**Consultation Response from KC,  
Lead Local Flood Authority**
**2021/93270 Land at, Station Road, Skelmanthorpe, Huddersfield, HD8 9BA**
**Discharge of conditions 3 (construction management), 4 (temporary drainage), 5 (temporary waste arrangements), 7 (adoptable roads), 12 (waste storage and collection), 13 (tree protection), 14 (units 23 and 24 revisions), 16 (detailed drainage scheme), 17 (phase II report), 18 (remediation strategy), 23 (materials) and 31 (vegetation removal) of previous permission 2019/91657 for erection of 30 dwellings**
**Date Responded: 16<sup>th</sup>  
September 2021**
**Responding Officer: Paul  
Farndale**
**Responding Ref:**
**Condition 4 – Temporary Drainage**

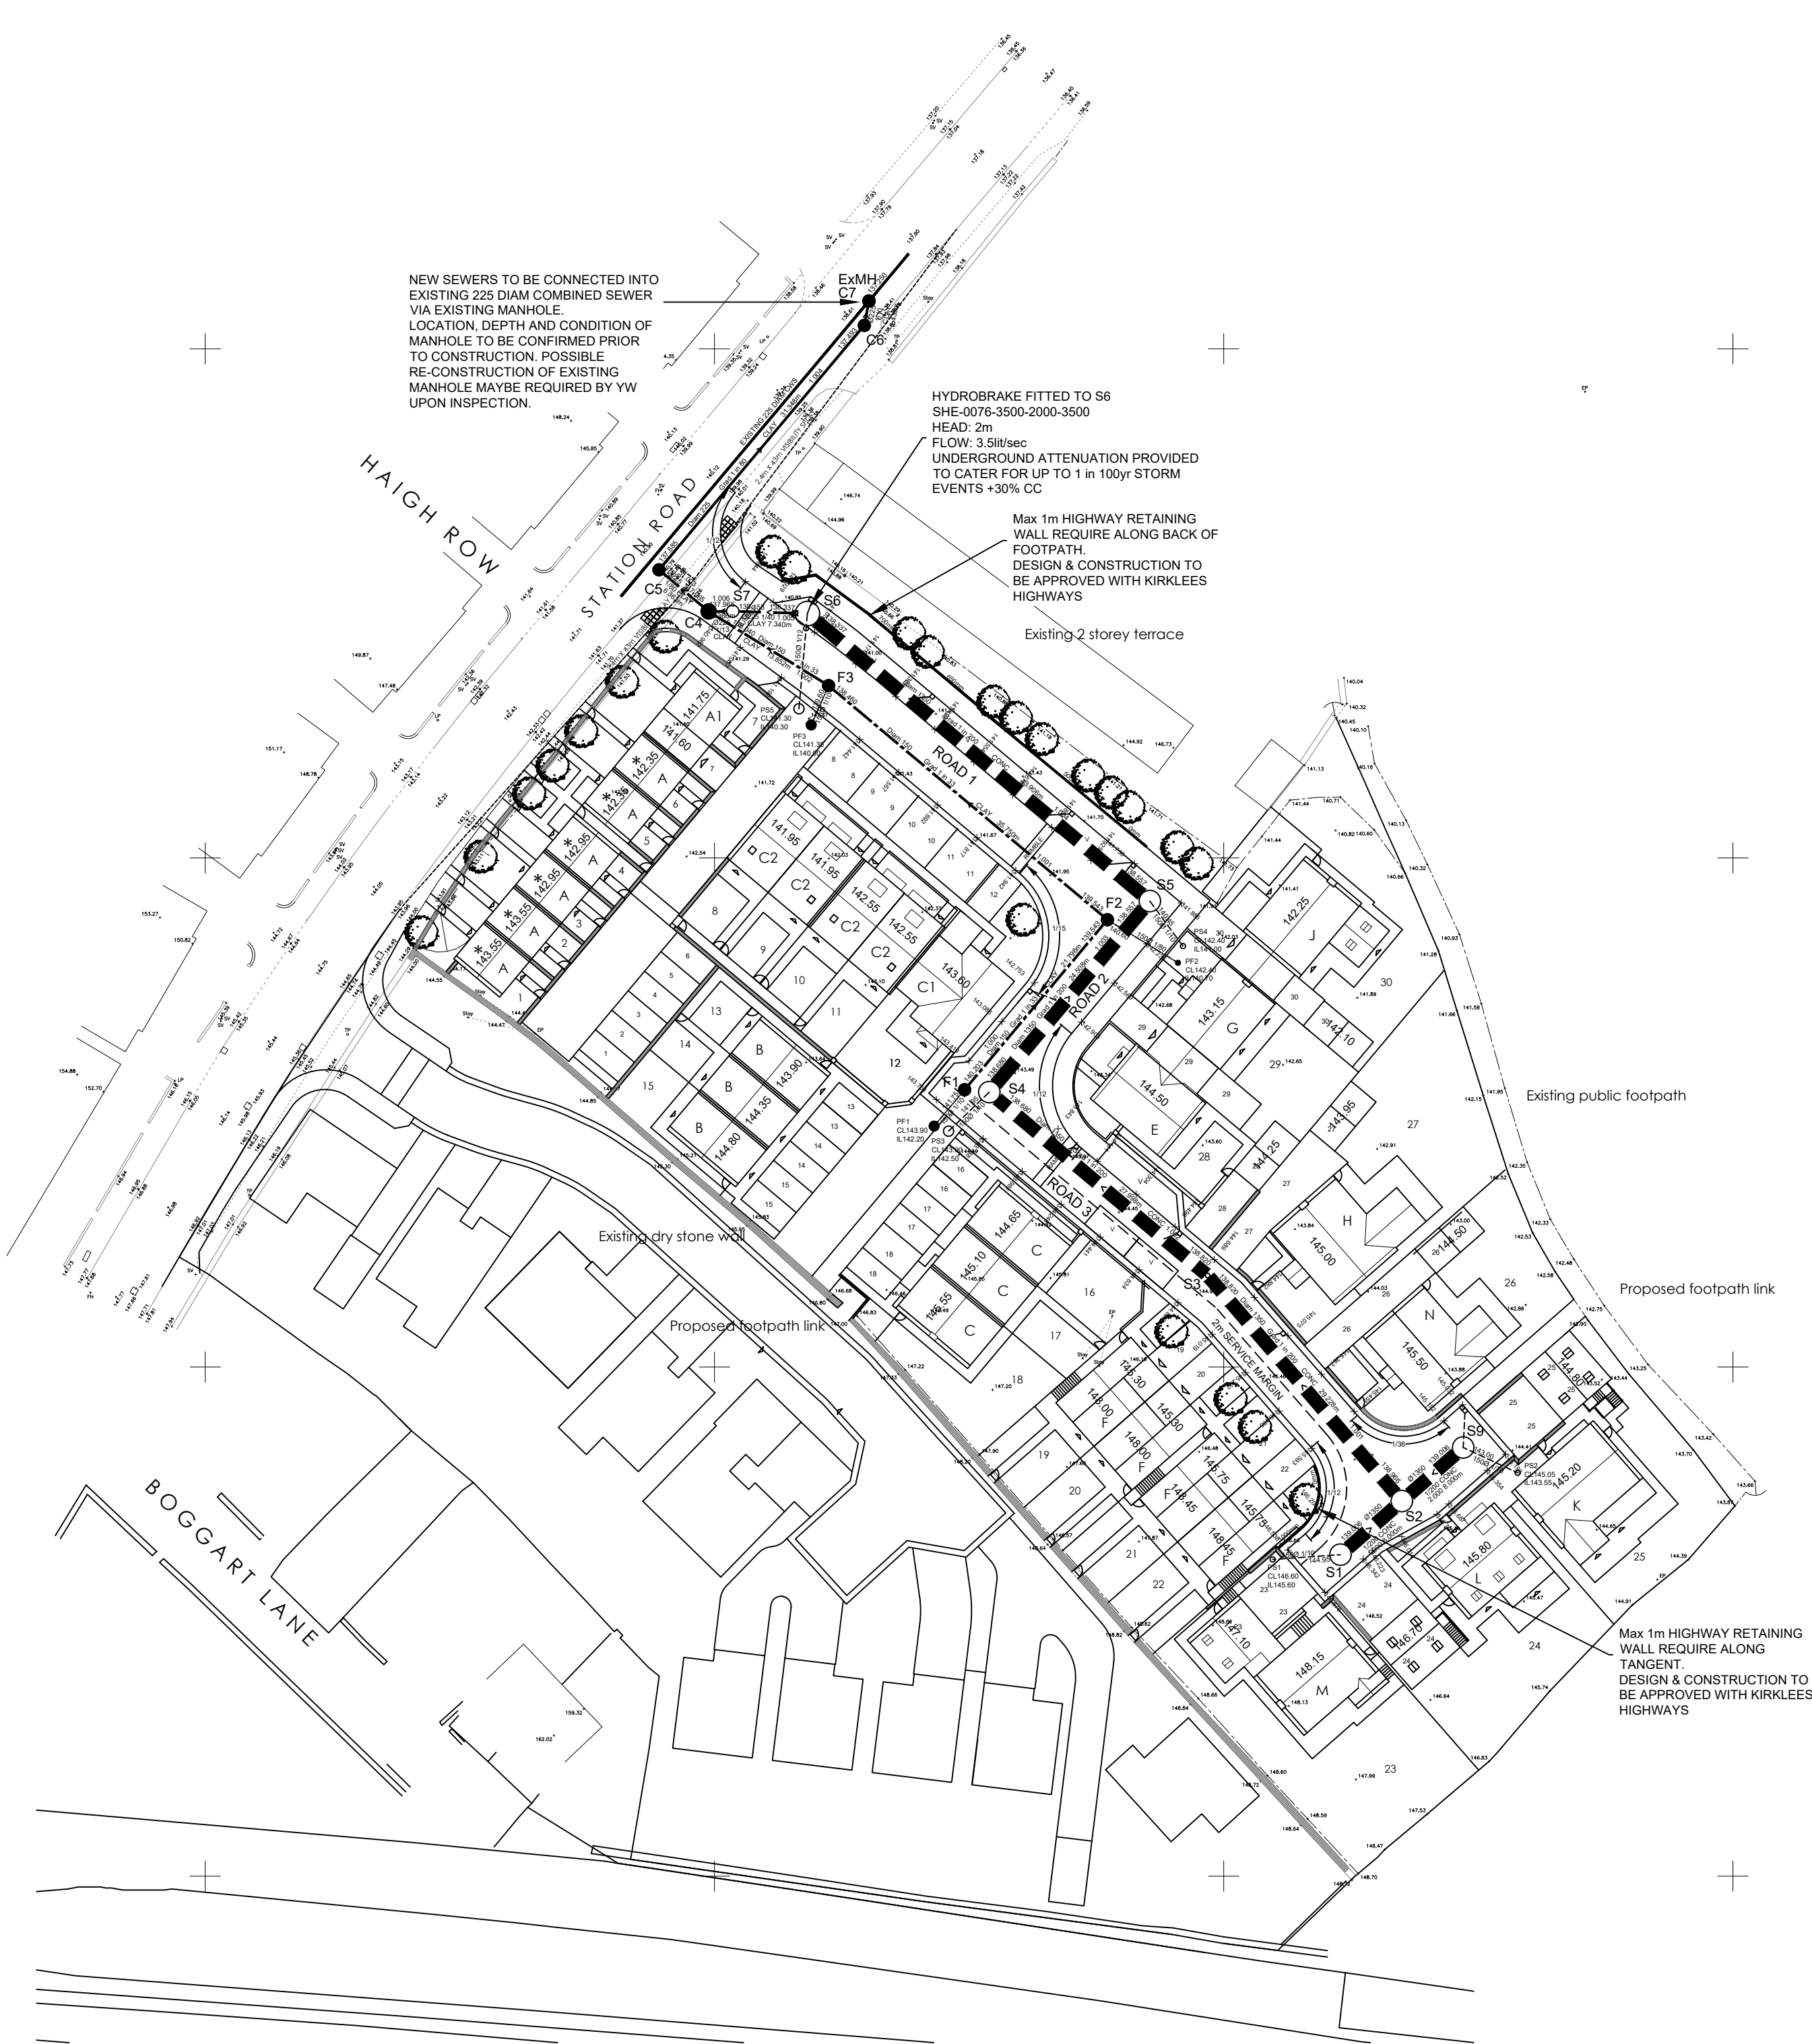
The LLFA accepts the drainage design. With regard to flood routing, further detailed information is required around the parking bay adjacent to plot 28 to ensure the low spot in this area is demonstrated by level including back of kerbs and to show that water if collecting at this point will weir over on the roadside and not into curtilage.

Similar evidence needs to be provided for the road narrowing around manhole S6

**Further information is required BEFORE this condition can be discharged.**
